SPR EA1N & EA2 PROJECTS

DEADLINE 8 - SASES POST HEARING SUBMISSION (ISH14 DAY 2) – BIODIVERSITY AND HRA

Interested Party: SASES

Date: 25 March 2021

- East Anglia ONE North and East Anglia TWO Onshore Development Area
- Work No 19
- Survey Area
- Target Note

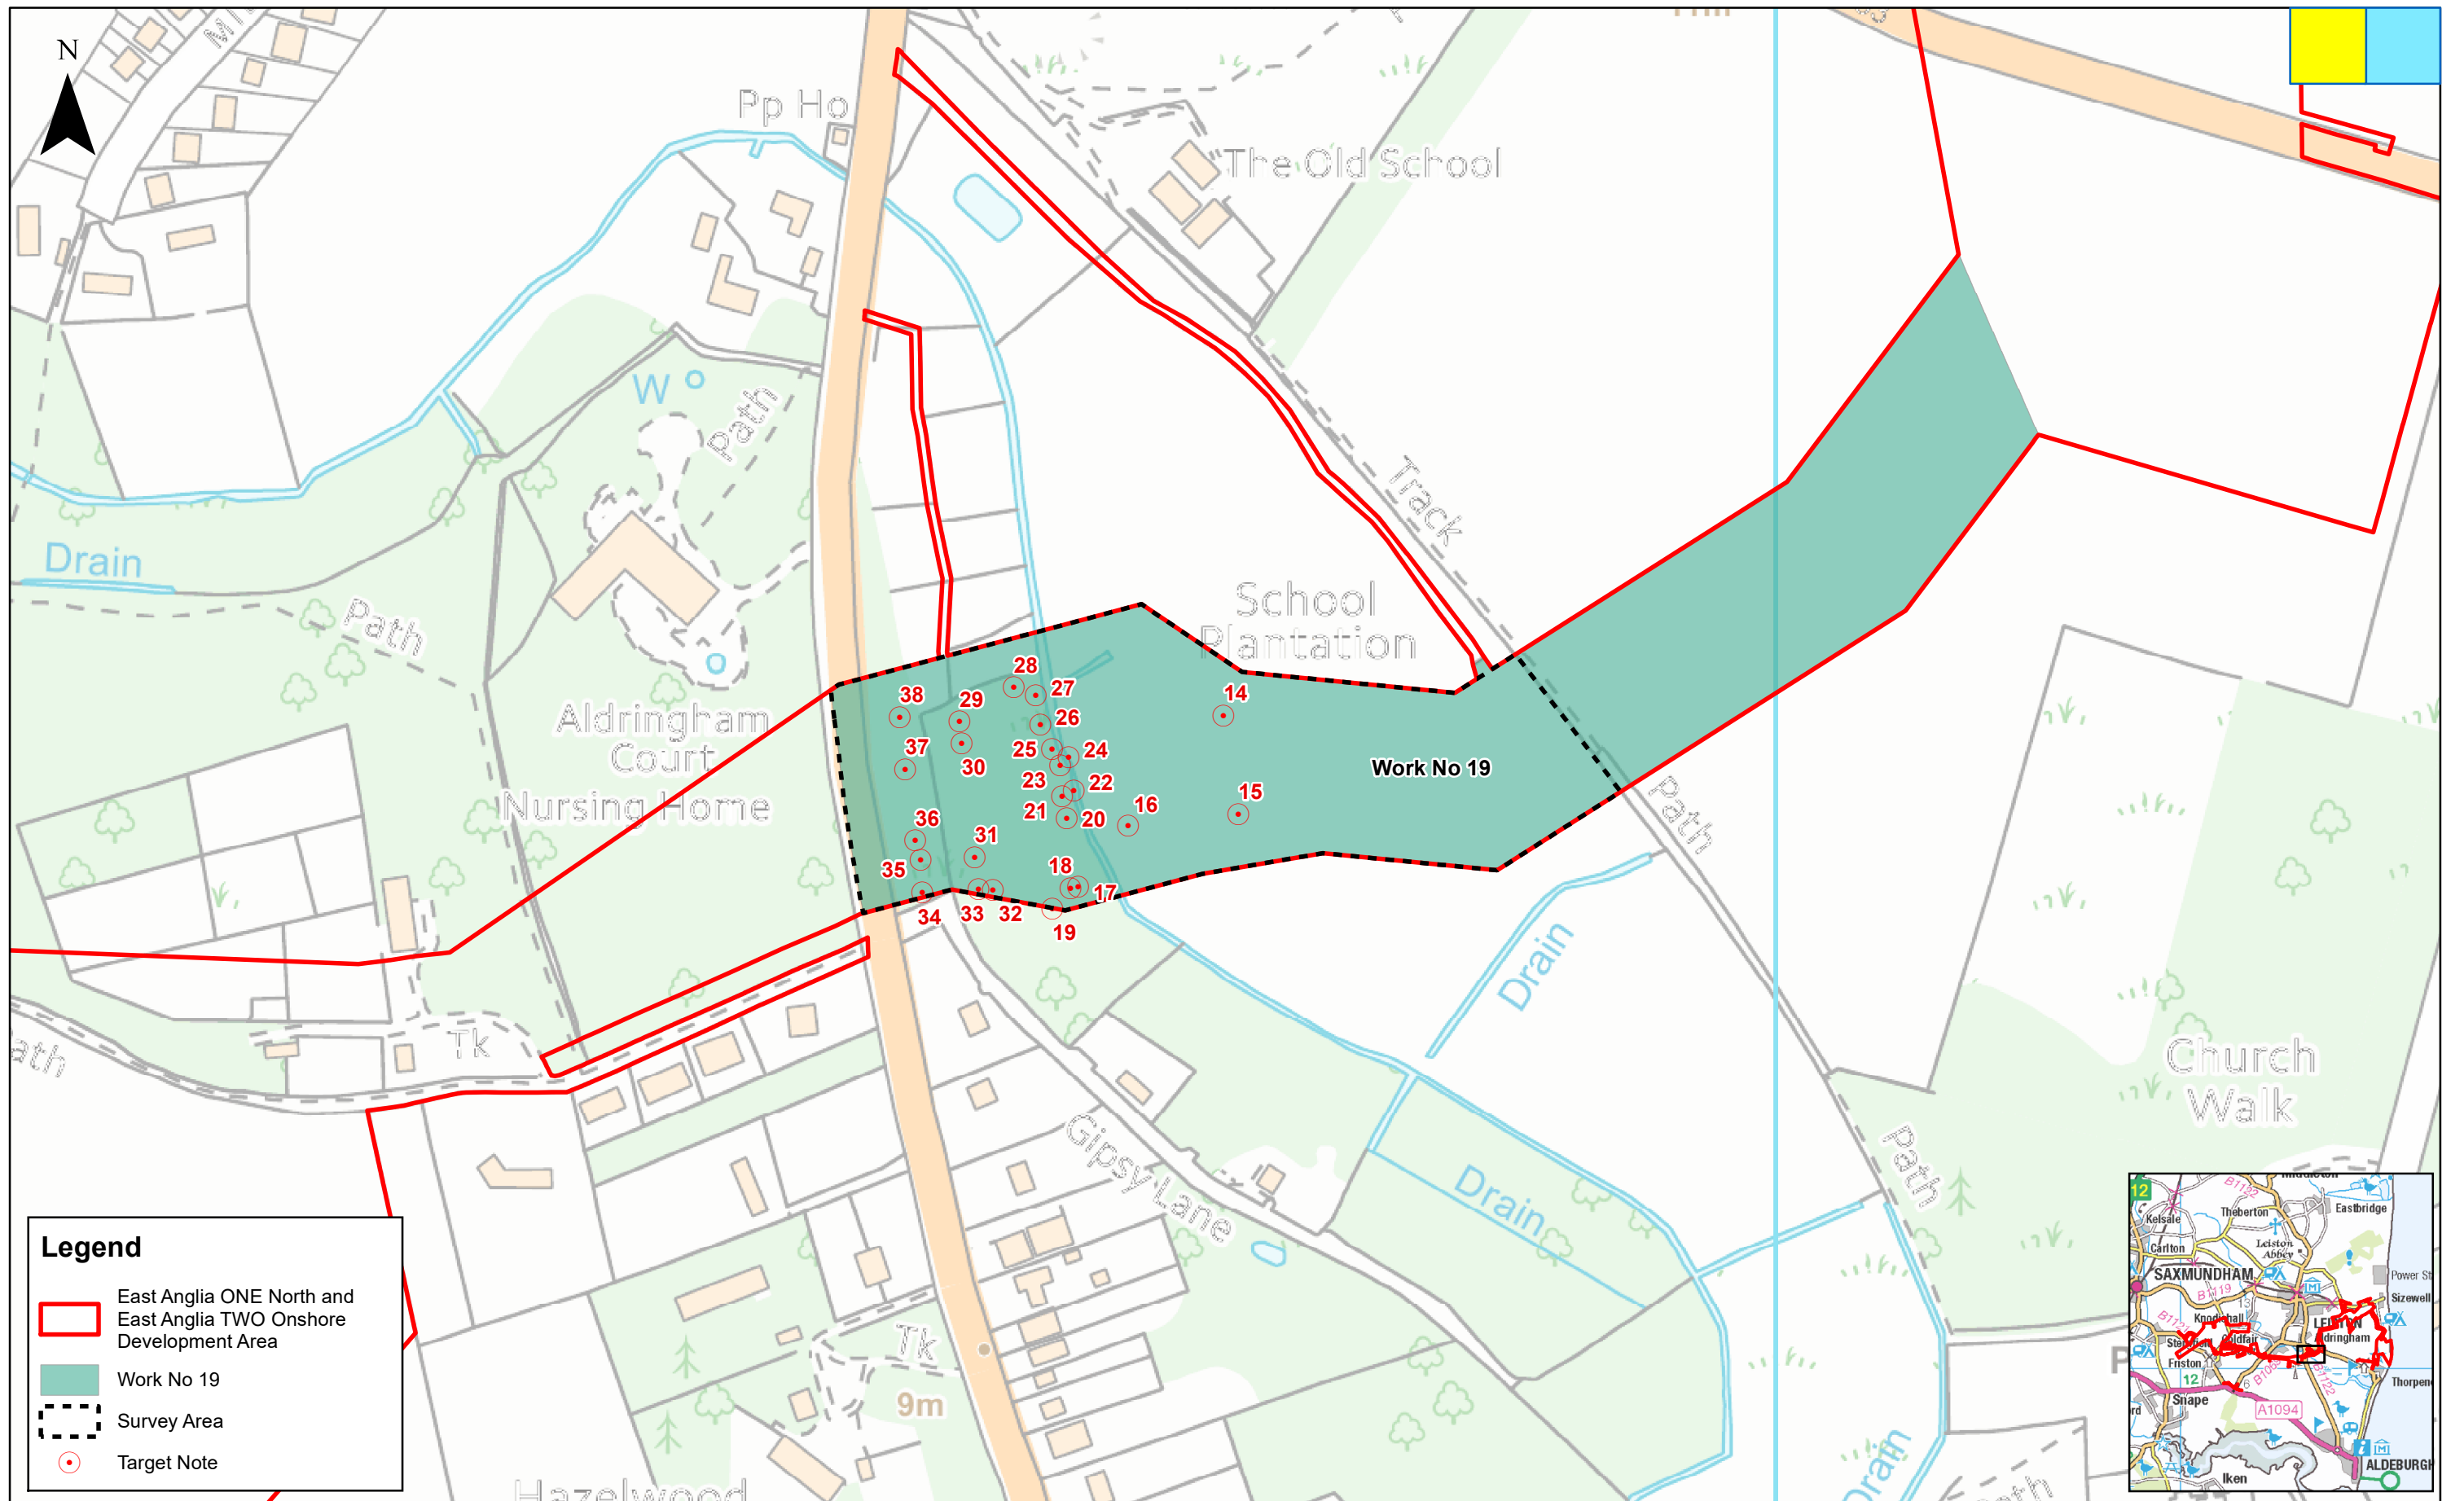
3. We await Natural England's further comments on whether the west bank of river may be wet woodland habitat and its opinion on whether the recent pre-ISH7 Royal Haskoning Ecologists' February survey was conclusive given that it was not carried out during the appropriate season. SASES expressed its concerns in 'SASES Deadline 7 Submission - Comments on Applicants' Deadline 6 submissions' [REP7-089] - Appendix 4: Applicants' D6 Ecology Survey Results, at page 14.

13. Not one single Target Note (TN) was identified on the west bank woodland at either phase of the 2018 Extended Habitats Survey, despite its rich biota habitats, many fallen trees etc.
Only one TN was plotted in the entire Works 19.
Reference: Figure 22.3.3c Extended Phase Habitat Map Results : **[APP-503]**, (Map of TNs in the Aldringham area).
That contrasts with the recent (Feb 2021) Royal HaskoningDHV pre-ISH7 survey which identified 25 TNs at Works No 19 of which 22 are within the woodland between river's west bank and the road.
References: Applicants' Deadline 6 Submission: 'EA1N&EA2 Ecology Survey Results - Version 01' **[REP6-035]**, Sheet 3 of Updated Ecology Survey Target Notes (map) and the Applicants' 'Written Summary of Oral Case ISH7' **[REP6-052]**.
